AQUIND INTERCONNECTOR

Statement of Common Ground Between
AQUIND Limited and Historic England

Document Ref: 7.5.13

DATE: 19 FEBRUARY 2021

EN020022-2.11-PARA-Sheet1	Application document reference 2.11 Optical Regeneration Station(s) Parameter Plan Sheet 1 of 1
---------------------------	--

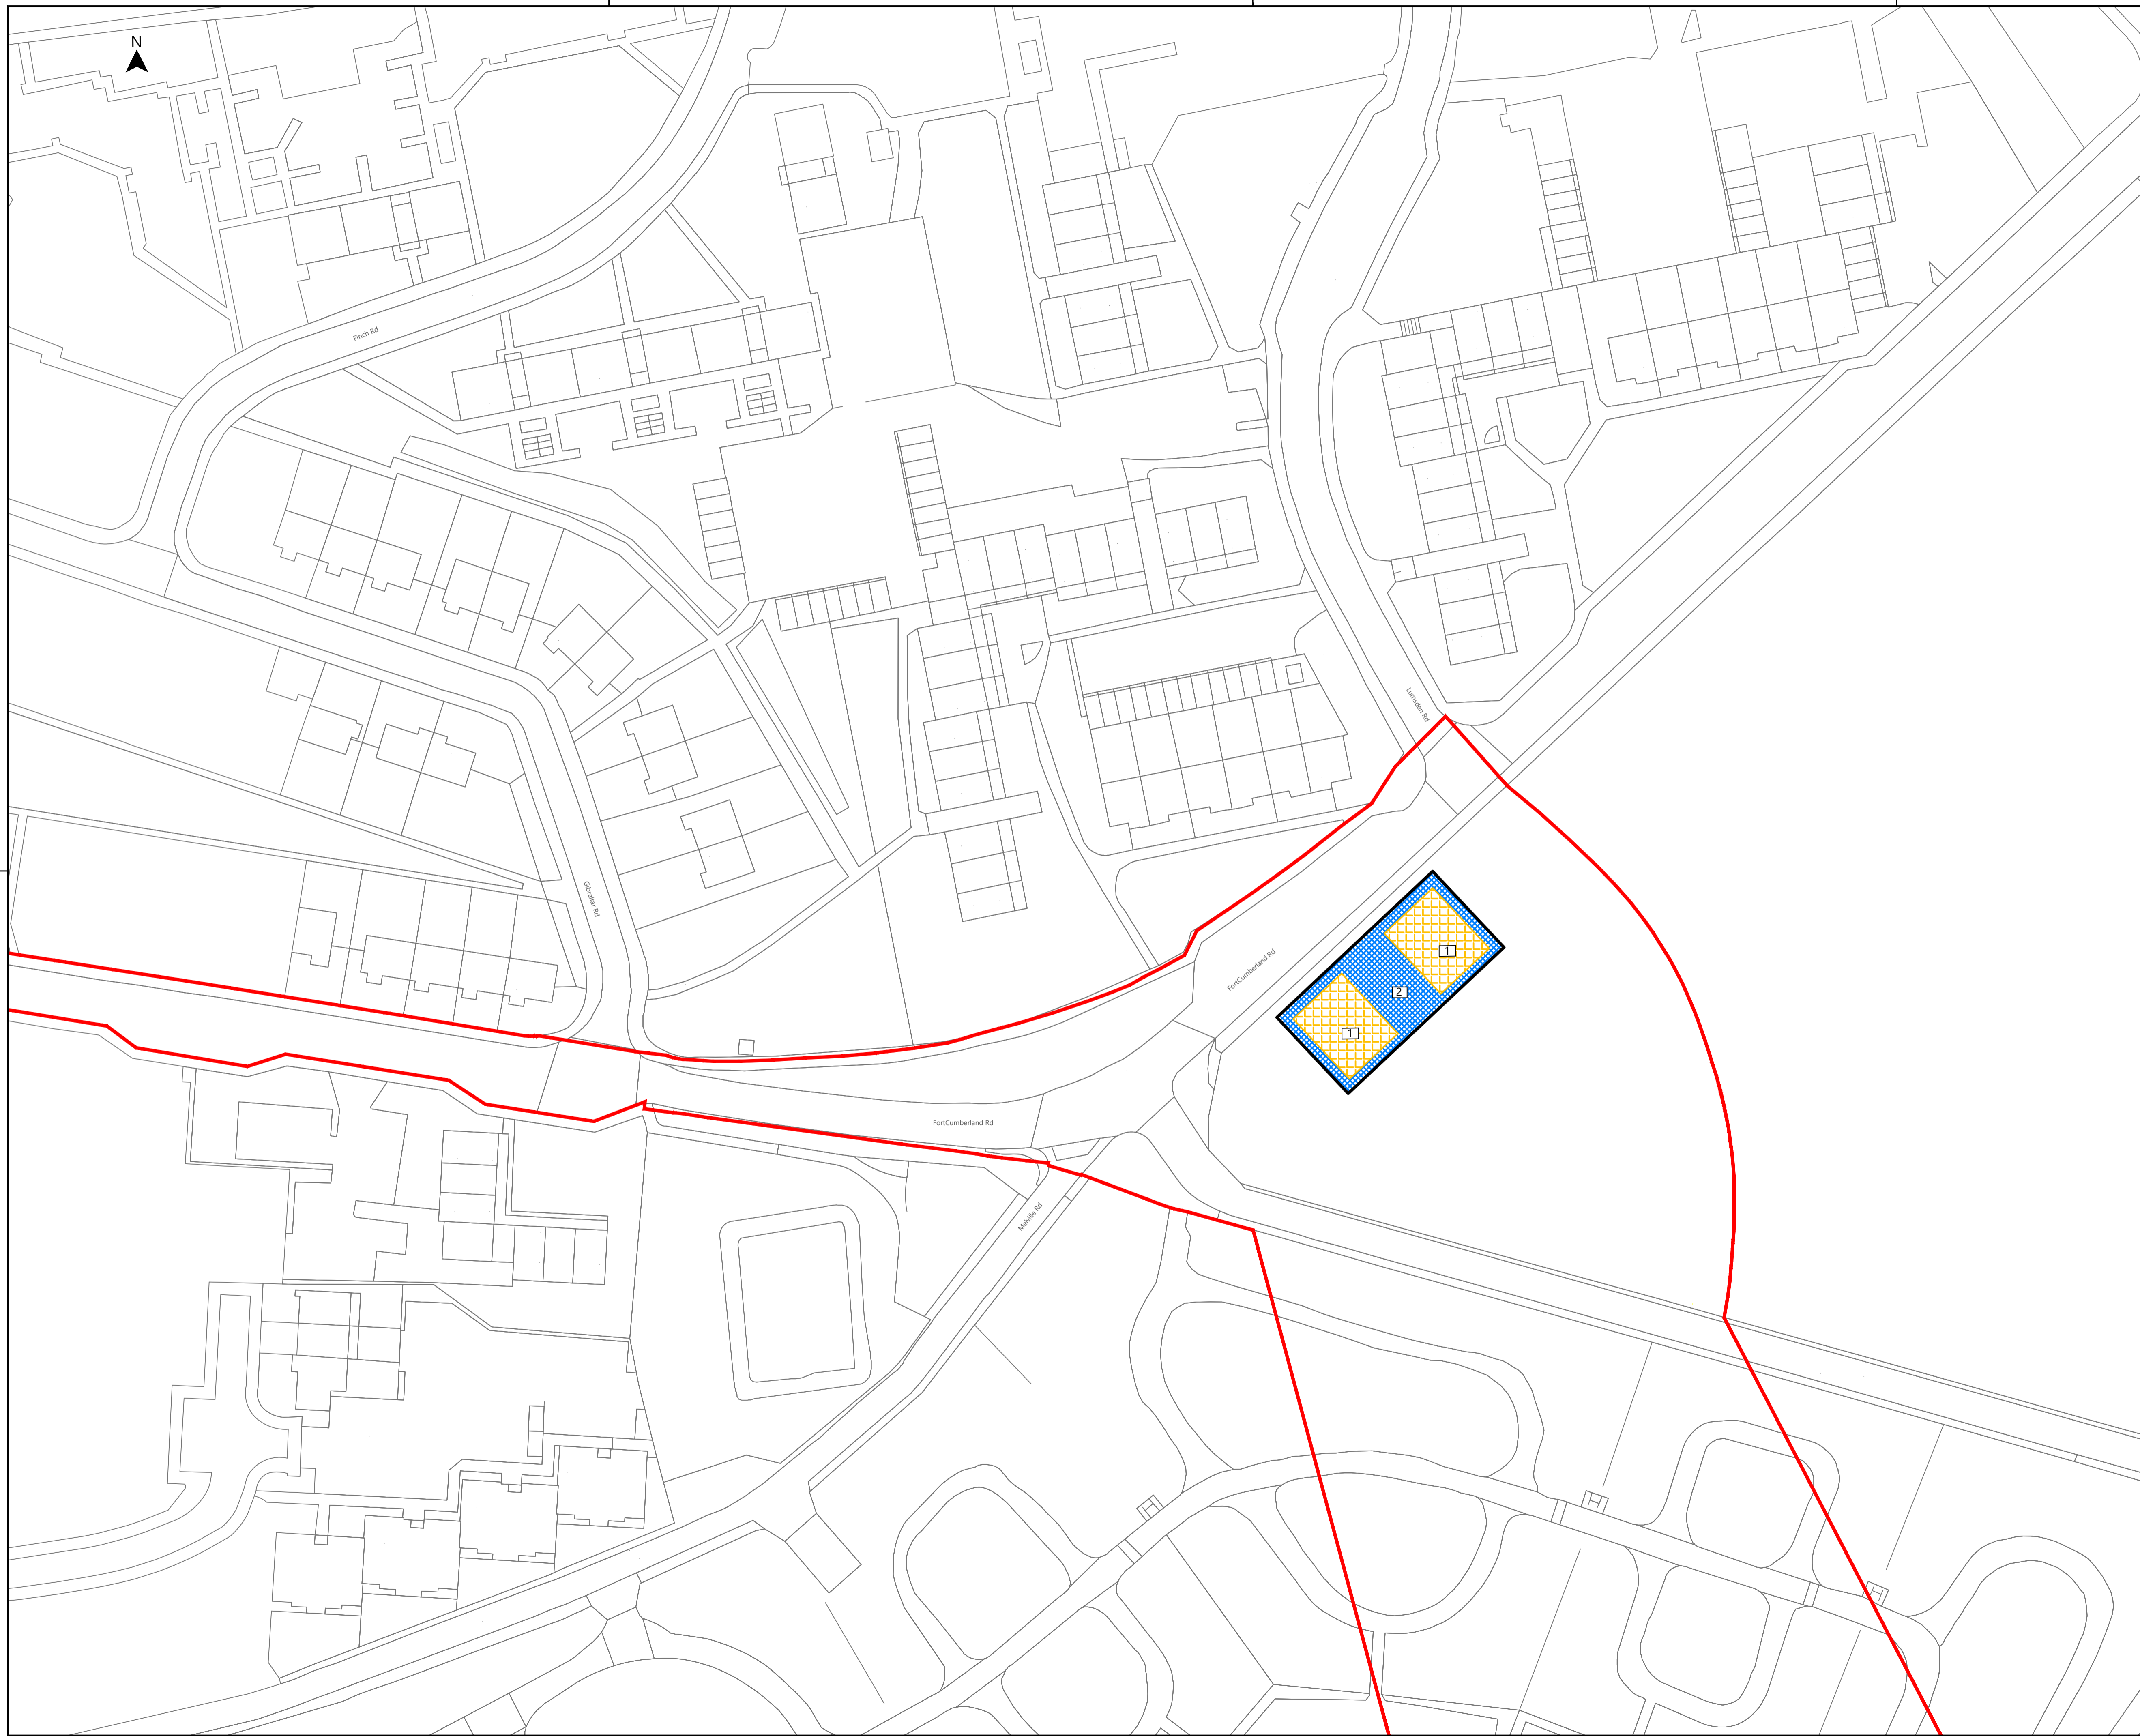
4.1.5	Landfall - Fort Cumberland, Setting (Level of Harm) (2)	<p>AQUIND position:</p> <p>The Applicant considers the impact to the significance of Fort Cumberland is negligible in respect of views from the western ravelin, based on the distance from the asset and the presence of a modern residential housing estate, located 15m to the north-west of the proposed ORS compound. The site of the proposed ORS compound is currently in use as a car park. The Applicant considers that the landward view from the western ravelin has been substantially altered since the construction of a 1960s housing estate (located 15m north of the Proposed Development) and 20th century motor shed adjacent to the north. The surrounding housing estate, trees and parked cars have significantly impacted the open coastal plain in views looking out from the western ravelin towards the Landfall and Fort Cumberland Road, including what were lines of fire from the fort. The location of the proposed ORS compound would introduce a new built form in long views out from the western ravelin towards Fort Cumberland Road. However, the proposed ORS would be lower in height than the current housing estate, and when seen against the background of the surrounding residential development would not be visually intrusive. Taken</p>	Not agreed

Ref.	Description of matter	Details of Agreement	RAG
		<p>overall, the ORS would not have a significant impact on how the asset is appreciated and understood. The overall environmental effect is therefore considered negligible.</p> <p>Following submission of the DCO application, It was agreed that an adjacent viewpoint would be used to provide further assurance that the significance of the fort would be unaffected, as access at the time was not possible due to Covid-19 restrictions. Landscape Viewpoint 22 was used to create photomontages showing the scale and massing of the two proposed ORS placement options (illustrated in Figure 15.56 of the Environmental Statement) (APP-289).</p> <p>An additional visualisation as agreed by Historic England was presented at Deadline 1 (Environmental Statement Addendum – Appendix 10 - Figure 5 Historic England Visualisations (REP1-141)). Although the Applicant acknowledges that the ORS would be visible in views from the western ravelin from Fort Cumberland, the overall effect as assessed in ES Chapter 21 (Heritage and Archaeology) (APP-136) remains negligible and as such the visualisation supports the conclusion of the settings assessment in ES Chapter 21 (Heritage and Archaeology) (APP-136).</p> <p>Historic England’s position:</p> <p>With regard to Fort Cumberland, Historic England consider there to be a level of harm, equating to less than substantial, which is higher than that suggested by the Environmental Statement. HE consider that the siting and scale of the ORS could cause some harm to the view from the western ravelin at Fort Cumberland towards Fort Cumberland Road. Historic England do not agree with how the level of harm has been identified in consideration of the particular relationship that exists between Fort Cumberland, its field of fire and, in particular, the visual association between the ravelin and the approach road from Portsmouth.</p> <p>Historic England note that sightlines, fields of fire, and connectivity with land and sea based approaches, are integral to the significance of the fort. Relationships with other fortifications alongside primary approach routes and attacking points confer additional context and coherence which also contributes strongly to Fort Cumberland’s significance. Historic England acknowledge that the setting of the fort was altered significantly during the mid-late 20th century, through residential development in the wider surrounding area. Despite this it is still possible to view,</p>

Ref.	Description of matter	Details of Agreement	RAG
		<p>appreciate and understand the landward approach to the site, via Fort Cumberland Road in particular, and its relationship with the monument. Historic England request to see the line of sight maintained to maximum extent, through the redesign or repositioning of the ORS.</p> <p>Outcome of further discussions</p> <p>This matter has been subject to further discussion between the parties following submission of the further visualisations contained with the ES Addendum at Deadline 1 (Document Ref 7.8.1). A teleconference meeting was held on 26 October 2020, where the additional submissions were discussed.</p> <p>Based on the additional information provided Historic England do not agree that the level of harm remains negligible and consider the impact to Fort Cumberland as ‘less than substantial harm’ (Overarching National Policy Statement EN-1 terminology). Historic England note that the visualisations do not provide an accurate representation of the view from the western ravelin itself, which is at an elevated position. As such, there is a possibility that the road convergence would be visible over the buildings from the ravelin, but this cannot be confirmed without a viewpoint from the ravelin itself. Historic England consider that the visualisations indicate (combined with viewpoint photos from the ravelin) that there would still be an impact on the view of Fort Cumberland Road even from the higher point.</p> <p>It has been agreed between the parties that the proposed Optical Regeneration Station (ORS) would not result in substantial harm to the Fort Cumberland Scheduled Monument and Grade II* listed building (see 3.1.5). Historic England maintain that the level of harm is less than substantial whilst the applicant considers the overall effect to Fort Cumberland scheduled monument is negligible. Irrespective of this differing professional opinion, in EIA terms the proposed change would not constitute a ‘significant’ environmental effect warranting substantial design amendments to the proposed scheme.</p> <p>The applicant will continue to consult with Historic England regarding reserved matters relating to building design such as materials and palette but do not consider further assessment work necessary. Following further discussion with Historic England, it was agreed that the draft DCO</p>

Ref.	Description of matter	Details of Agreement	RAG
		<p>text would be amended to make provision for consultation on reserved matters relating to the construction of the ORS. The proposed draft text was subsequently agreed by both parties.</p> <p>As outlined in Section 5.8 in (EN-1) it will be for the examining authority to decide whether any perceived harm has clear justification, in order to weigh that perceived harm against the public benefits of the development. The applicant makes note of the Needs and Benefits Addendum (Document Reference 7.7.7), which outlines the national scale benefits of the Aquind Interconnector.</p>	
4.1.6	Residual Effects	The residual effects identified in section 21.9 and table 21.6 of Chapter 21 of the ES (Heritage and Archaeology) (APP-136) are agreed.	Agreed
